**City of Portland, Maine - Building or Use Permit**

Permit No: 10-1349	Date Applied For: 10/27/2010	CBL: 163A A016001
-----------------------	---------------------------------	----------------------

Proposed Use: Duplex - Build new Duplex each unit 3 bedroom, 2.5 Bath No Garage	Proposed Project Description: Build new Duplex each unit 3 bedroom, 2.5 Bath No Garage
--	---

DETAIL A  
 PARTY WALL

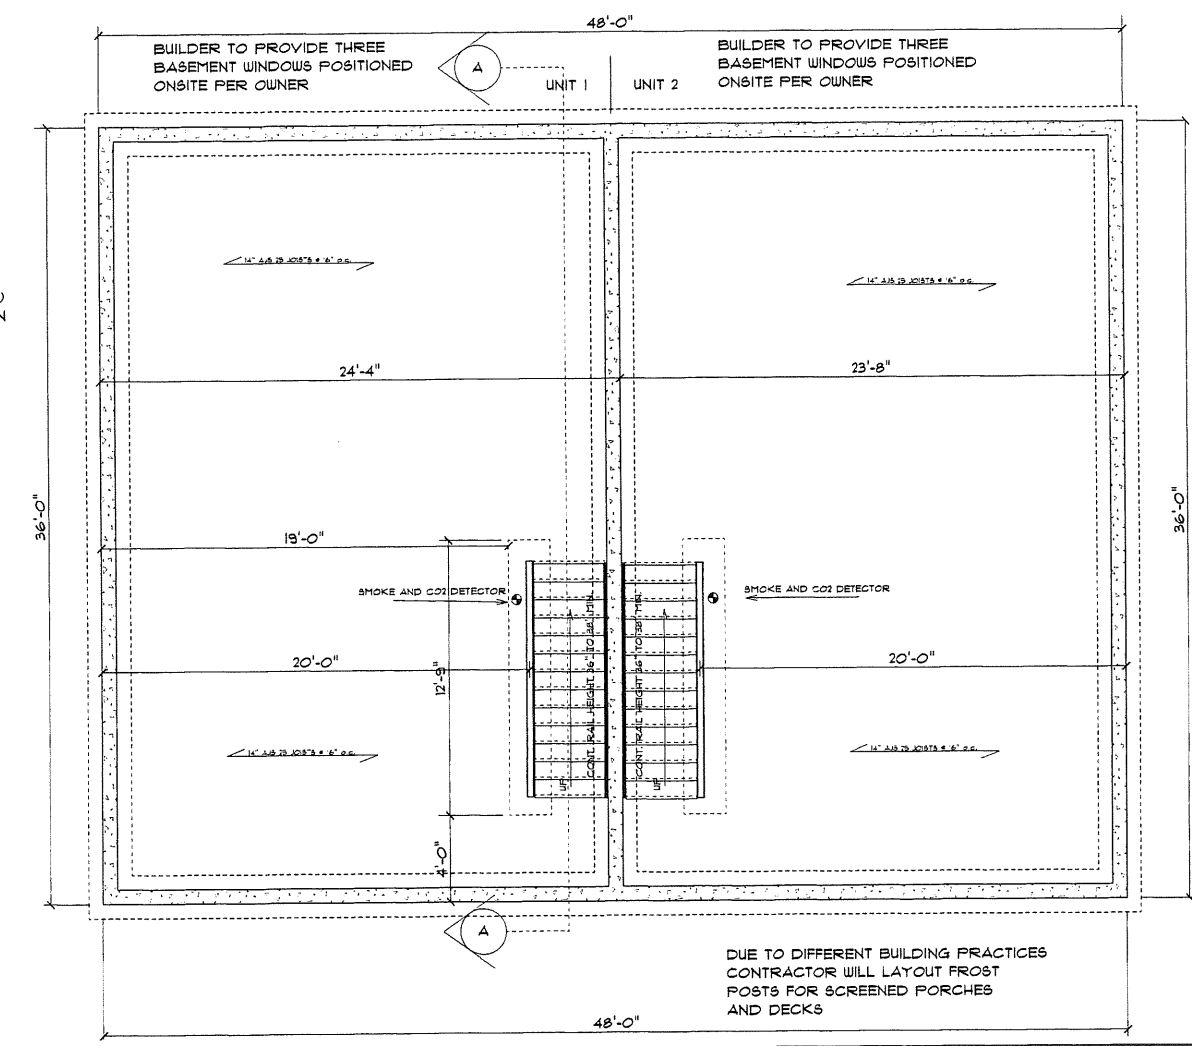
11/29/2010-jmb: Left vcmg for Bob N. For items on review checklist including, a full section of the demising wall showing continuity, extension of fire partition wall to the exterior wall sheathing, sprinkler system.

FRONT ELEVATION

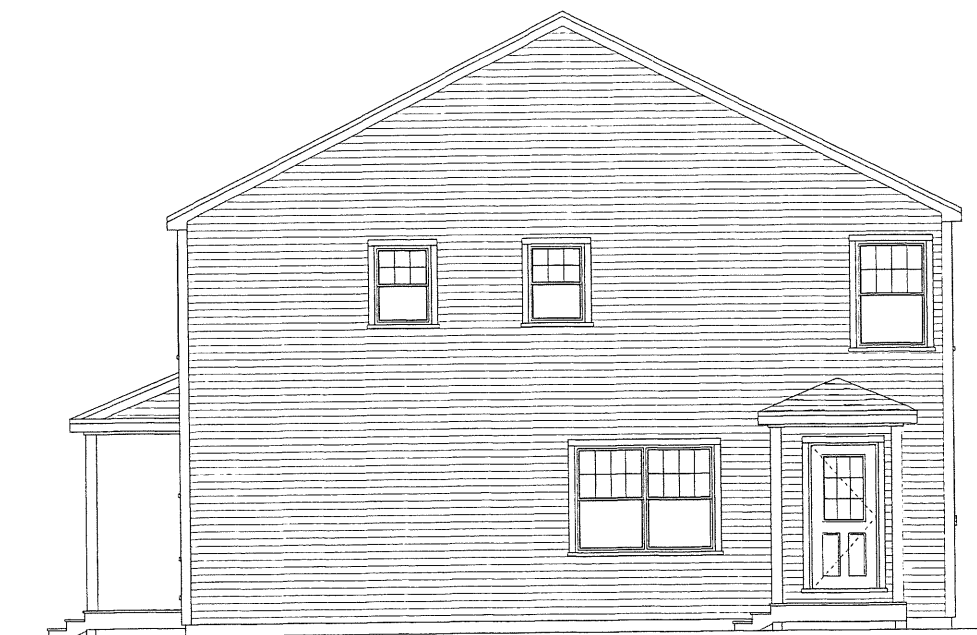
10/28/2010-amachado: Spoke to Bob Nelson. Need a copy of the contract for 5' strip of land. Need deed description for the new lot. Front porch on the site plan does not match the building plans.

**SITE PLAN**  
AT  
38 MORSE STREET, PORTLAND, MAINE  
MADE FOR  
**ROBERT C. NELSON**  
47 ALICE COURT, PORTLAND, MAINE

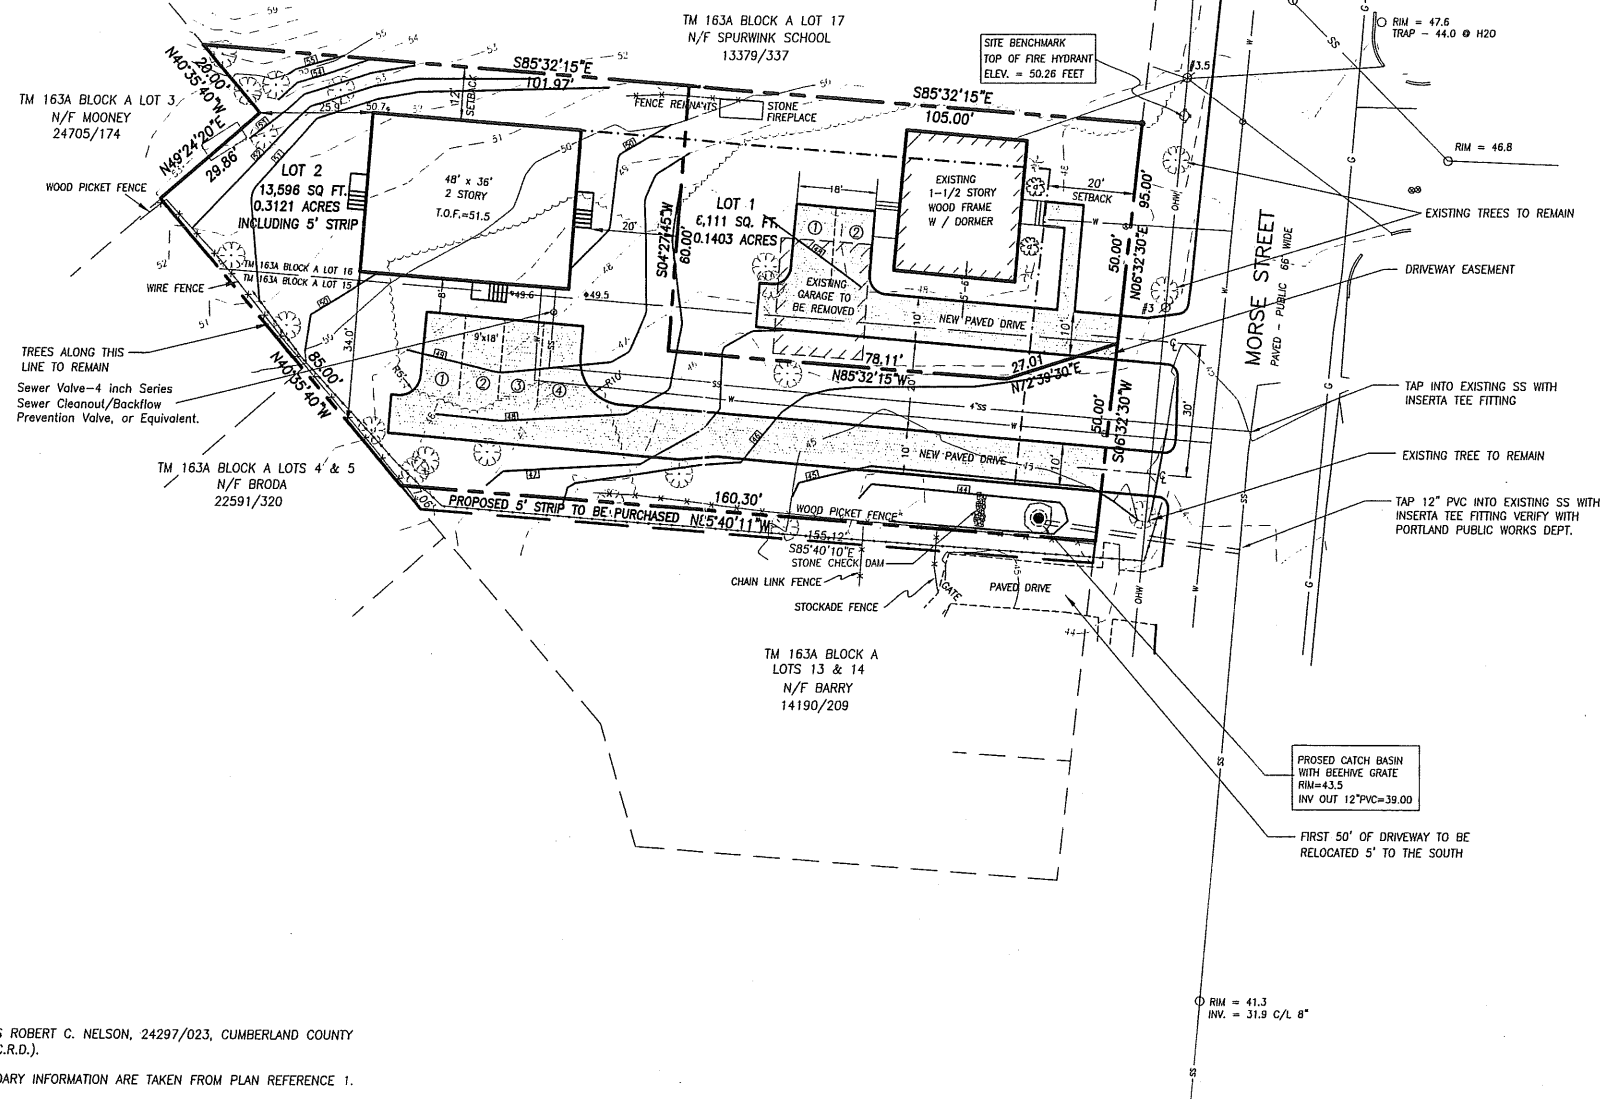
10/29/2010-amachado: Received purchase & sales for 5' wide strip of land to be added to left side of property. Moving permit forward in review process. I can't sign off until revise front porch on site plan & submit deed description for new lot.

1/24/2011-amachado: Received revised site plan from Jean Fraser. Building has been moved forward on site plan and parking has changed. The front yard setback now scales at 20' to the building. The entry porch can only be located in the front yard if it is 50 square feet or less. The side entry scales at 6' x 9' which is over 50 square feet allowed. Building plans show both side entries as 5' x 8'. Both are now 6' wide. Still can't sign off but giving it back to Jeanie for now.
